SCOPING OPINION

Proposed Tavistock to Bere Alston railway reinstatement and associated trails

December 2014

This report sets out the Secretary of State's opinion on the basis of the information provided in the Devon County Council ('the applicant') report entitled Environmental Impact Assessment Screening and Scoping Report (October 2014) ('the Scoping Report'). The Opinion can only reflect the proposals as currently described by the applicant.

Boundary of land affected by the railway re-instatement component of the project.

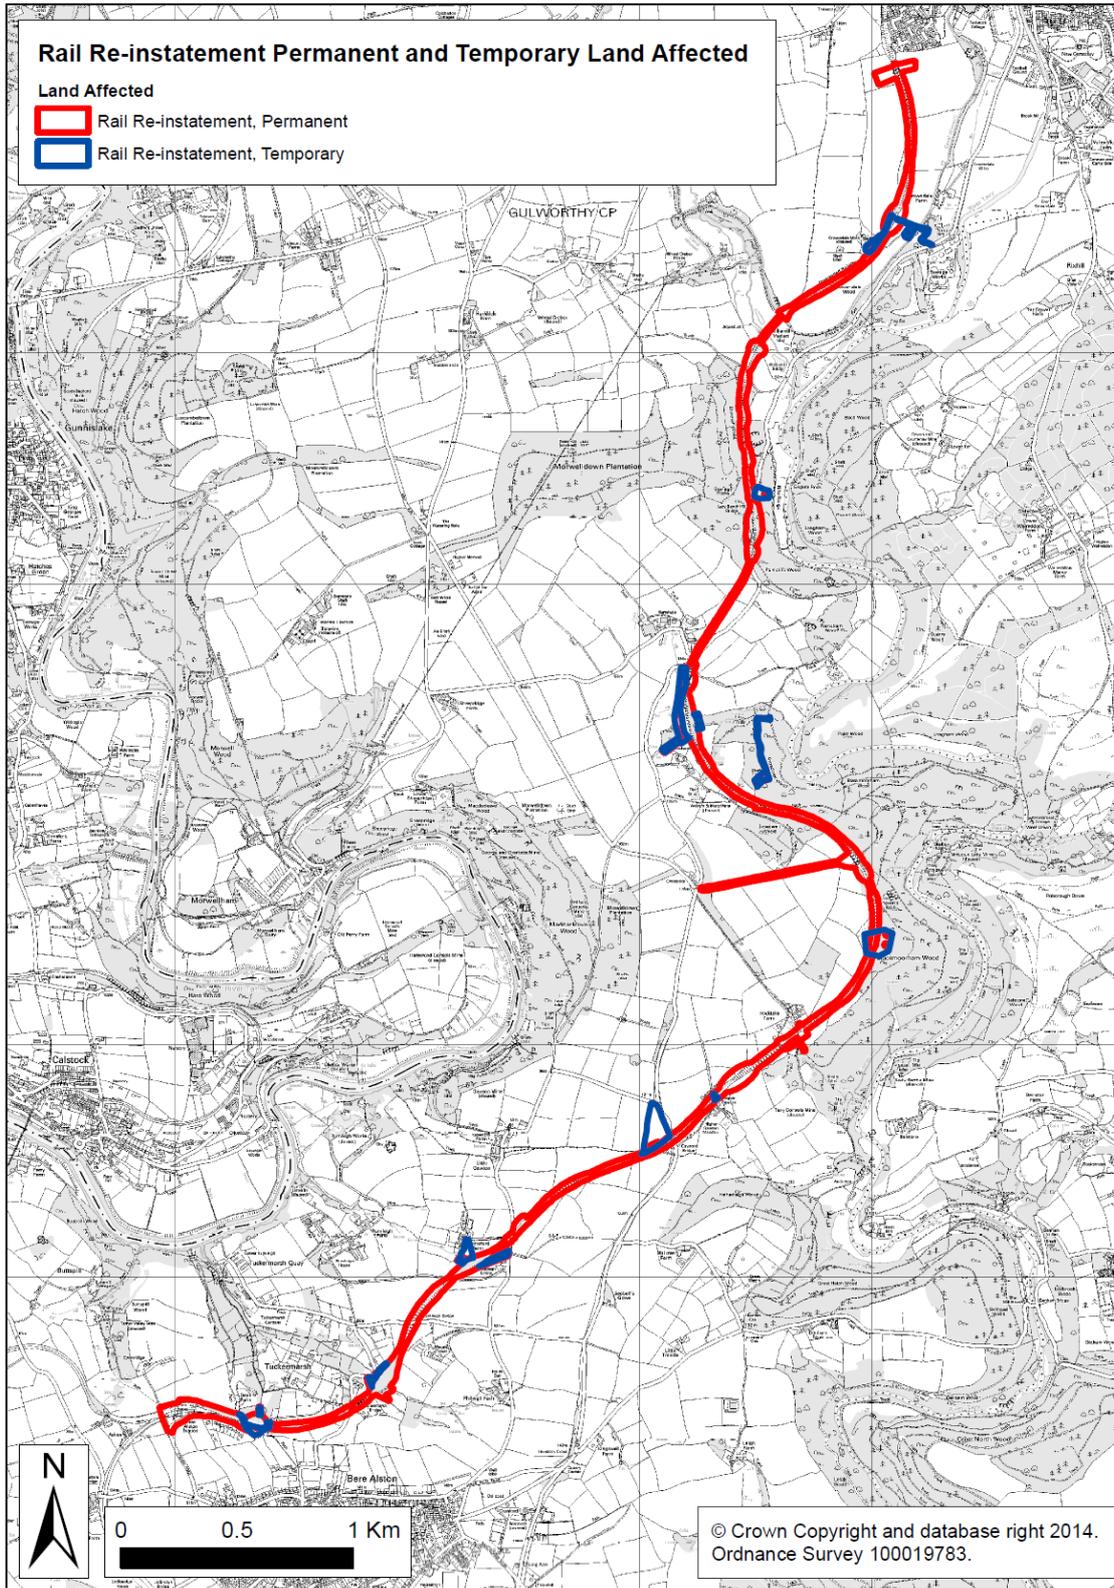
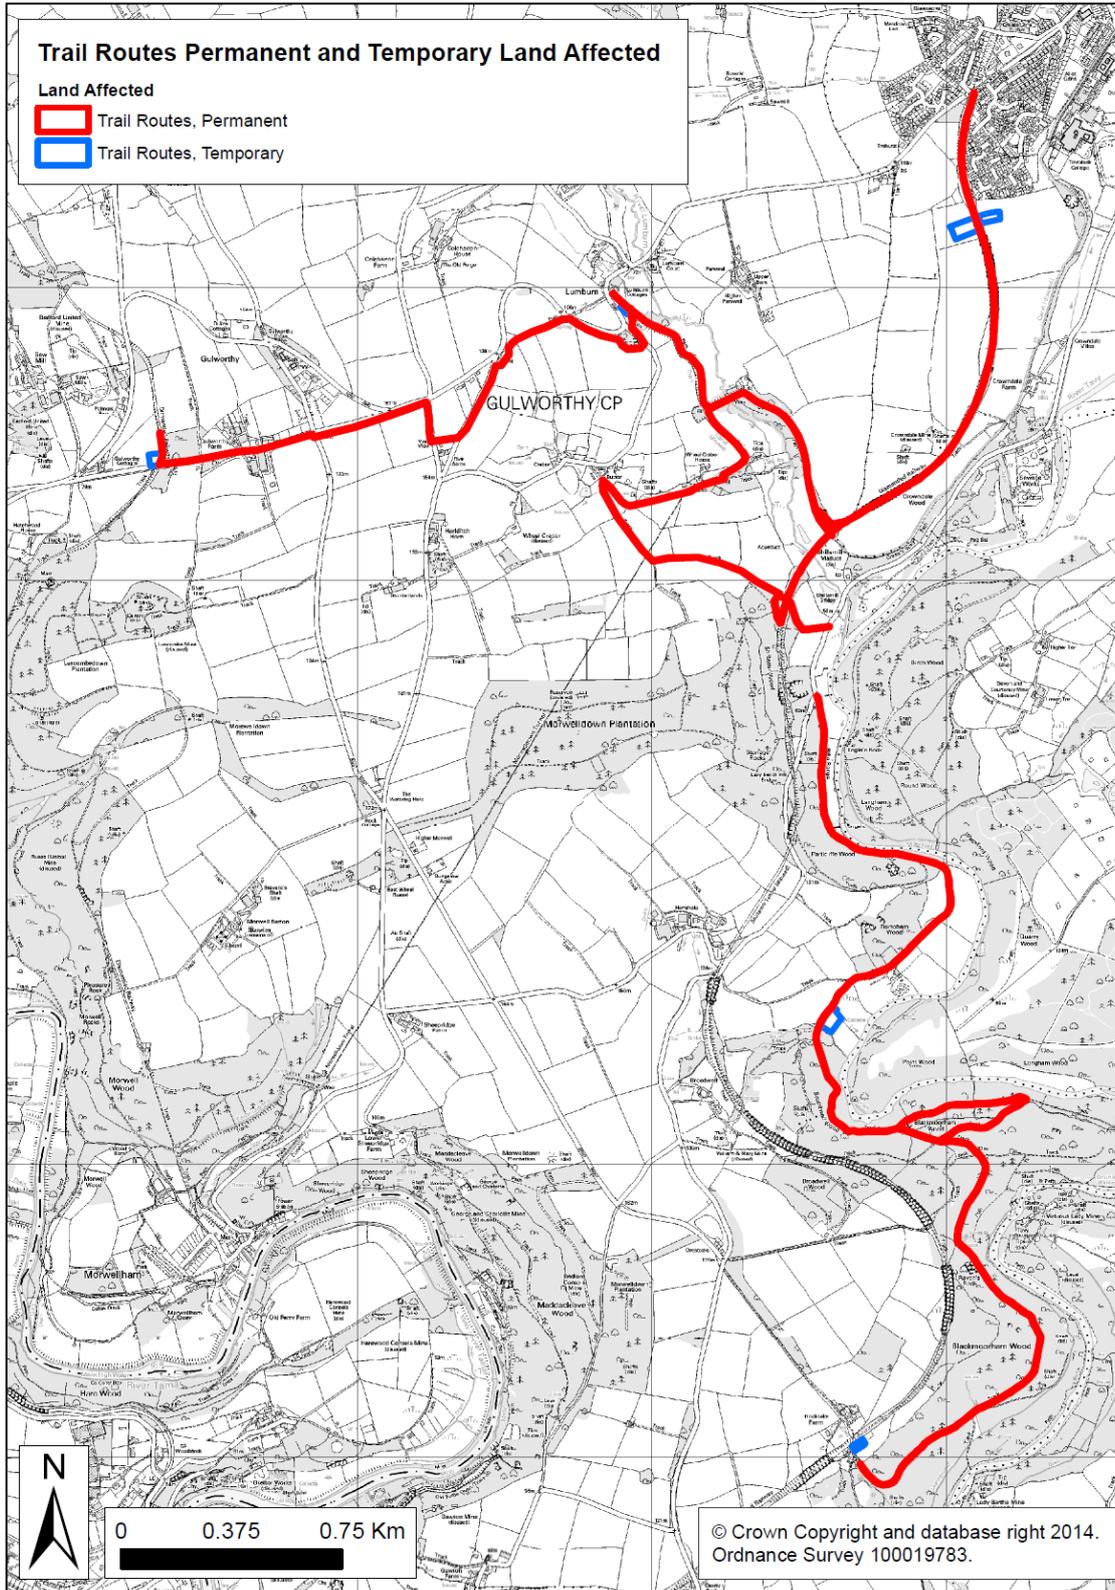
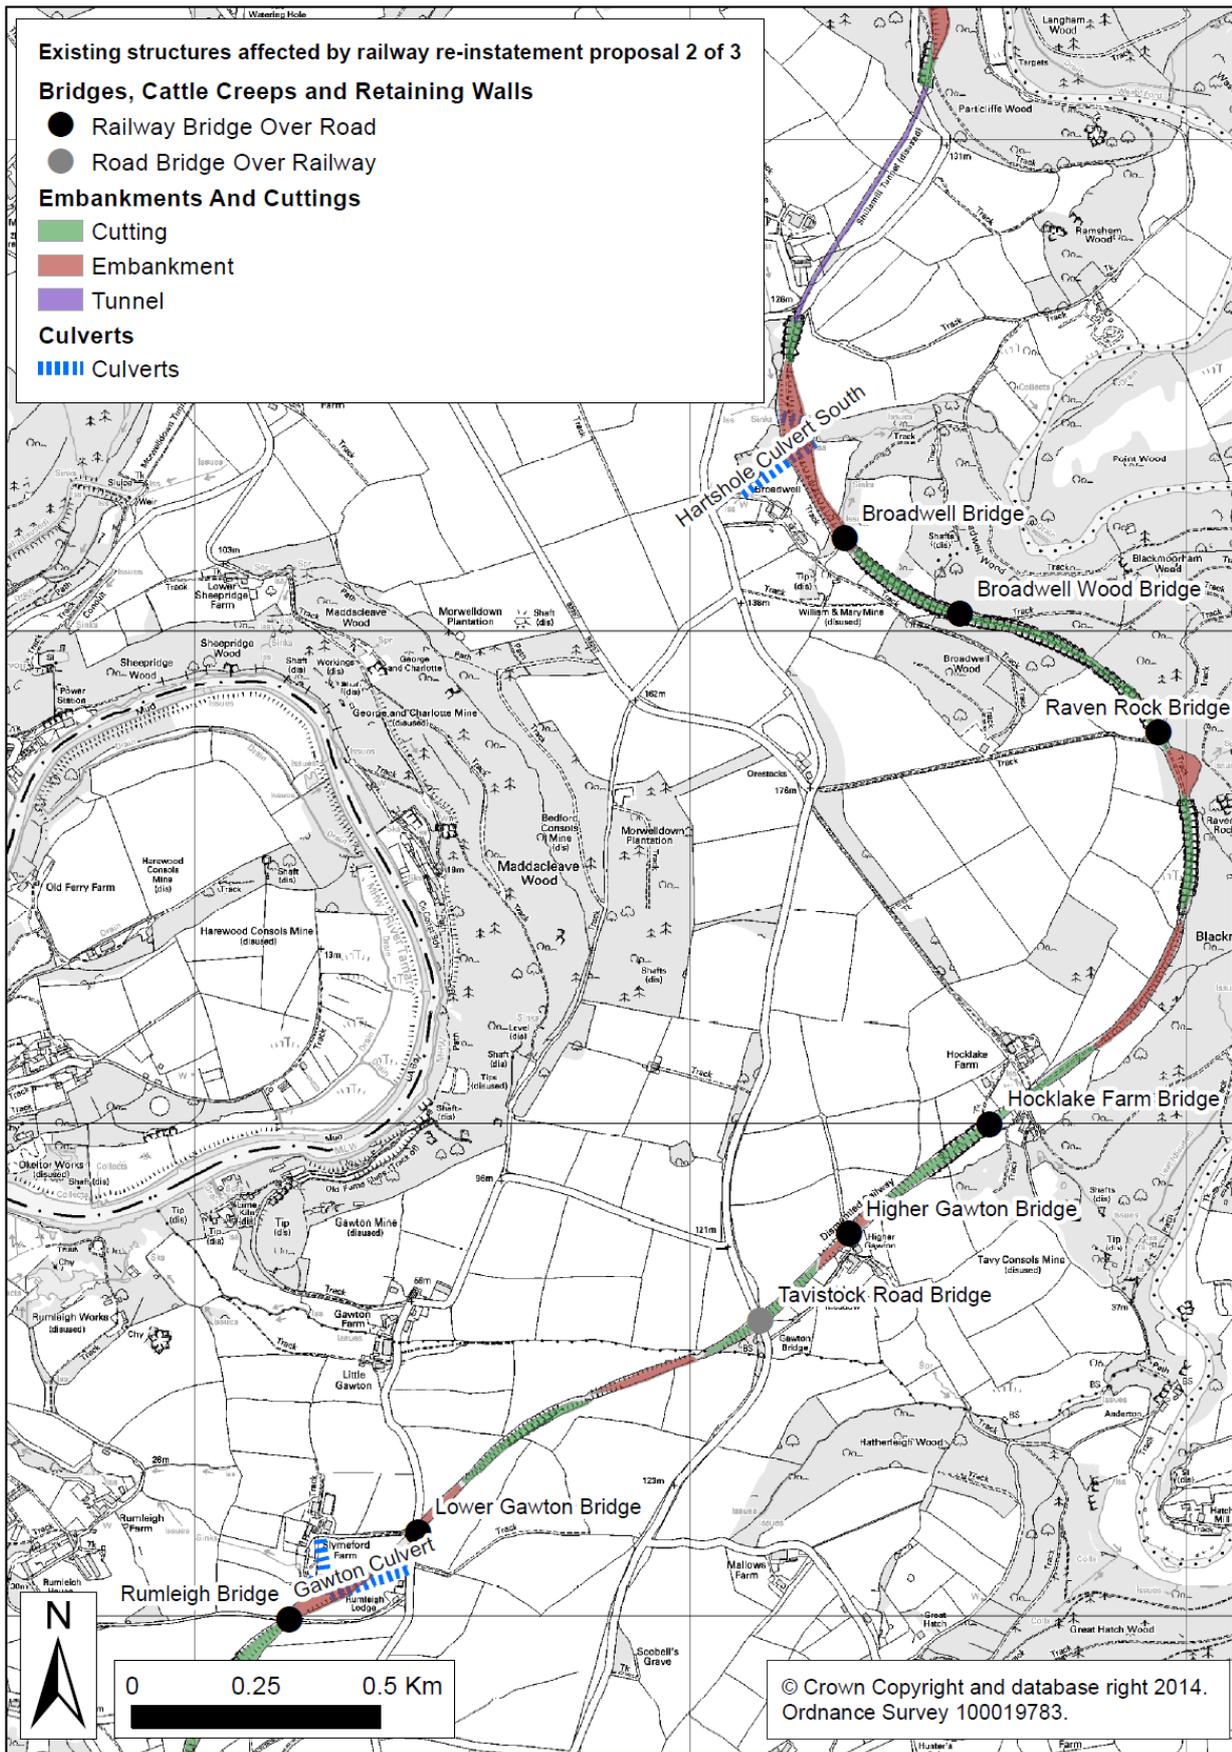
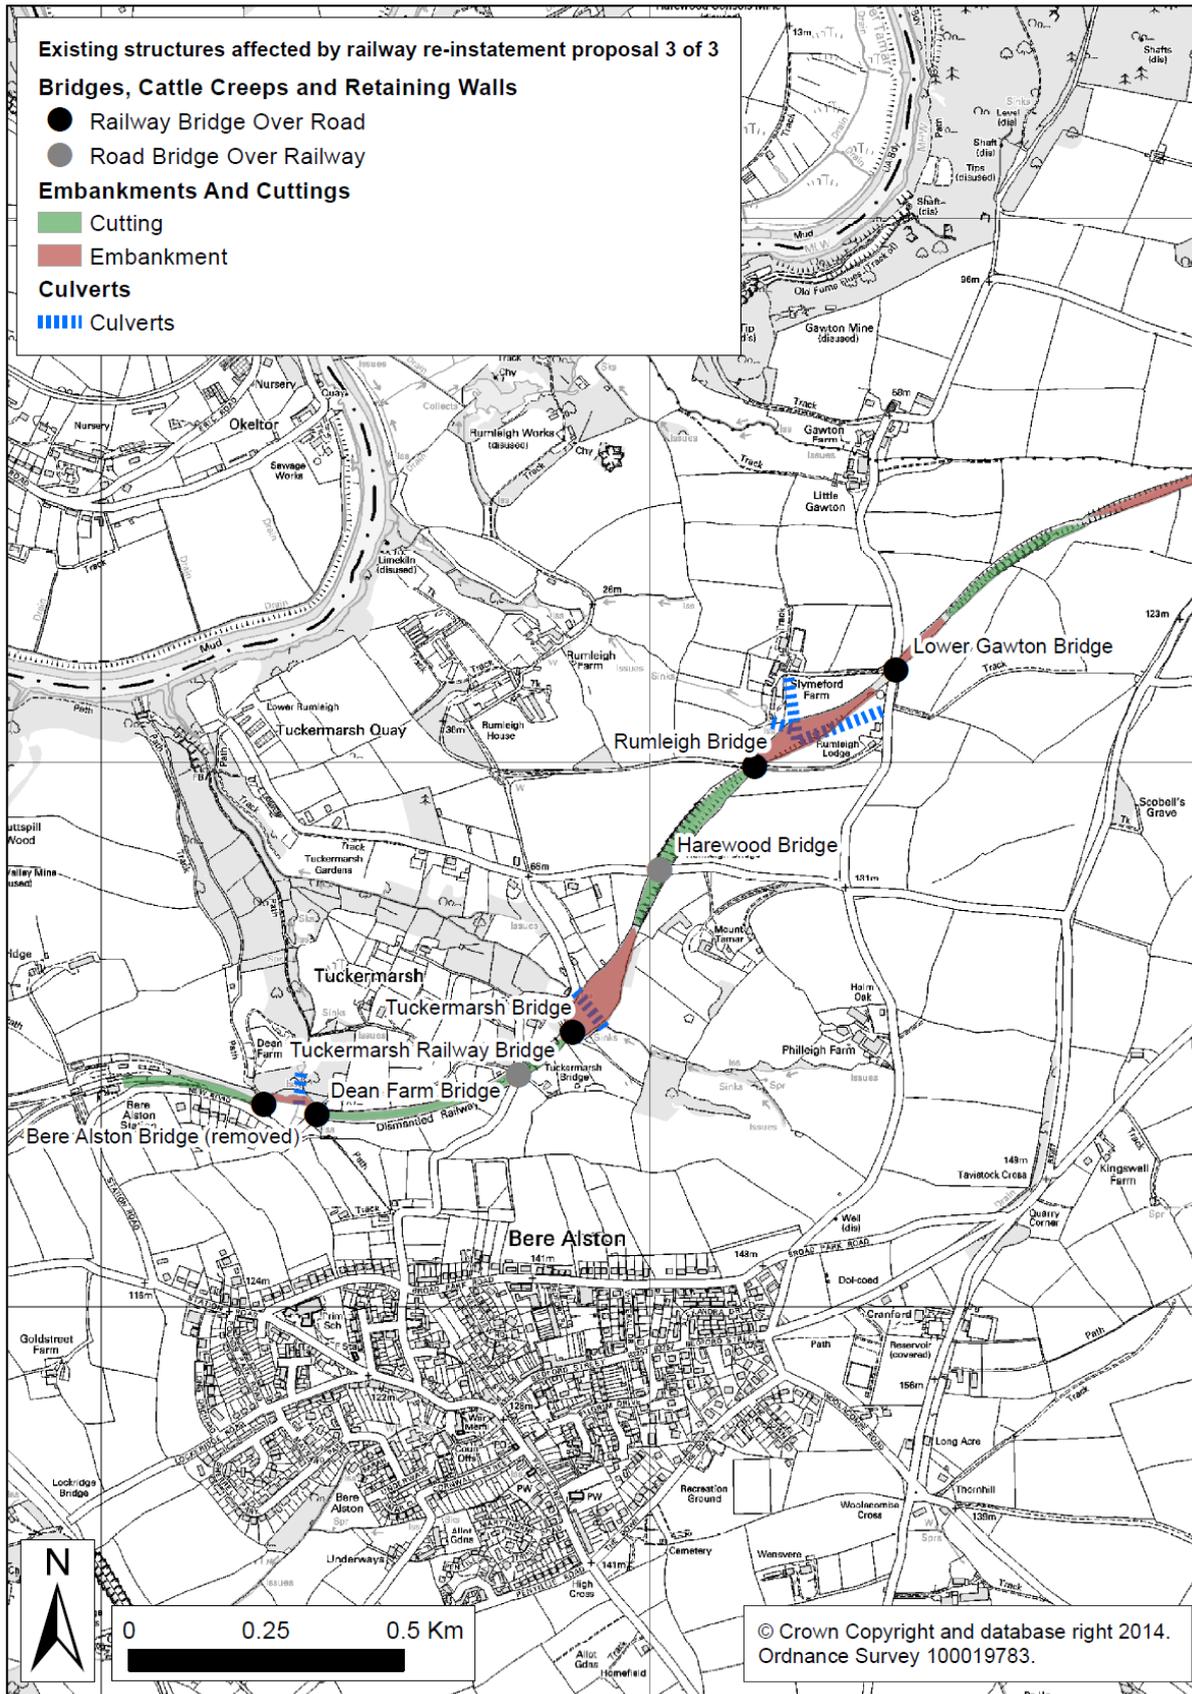
- 2.34 The Secretary of State welcomes the use of figures in the Scoping Report to support the description of the application site and surrounding area. Red line plans are provided at Appendices B and C of the Scoping Report, illustrating the land affected by the rail re-instatement and by the trail routes respectively. For clarity however the following approach is recommended:

- A single red line plan should be provided to illustrate all land affected by the proposed works, including the rail reinstatement route, trail routes and any temporary works.
- All figures should be clear and legible; where there is a lot of environmental information to present, this should be arranged over a number of figures to limit the amount of overlaid information and to avoid confusion.
- All features on figures should be clearly labelled, identifying not only the location of certain designations, but also the specific name.
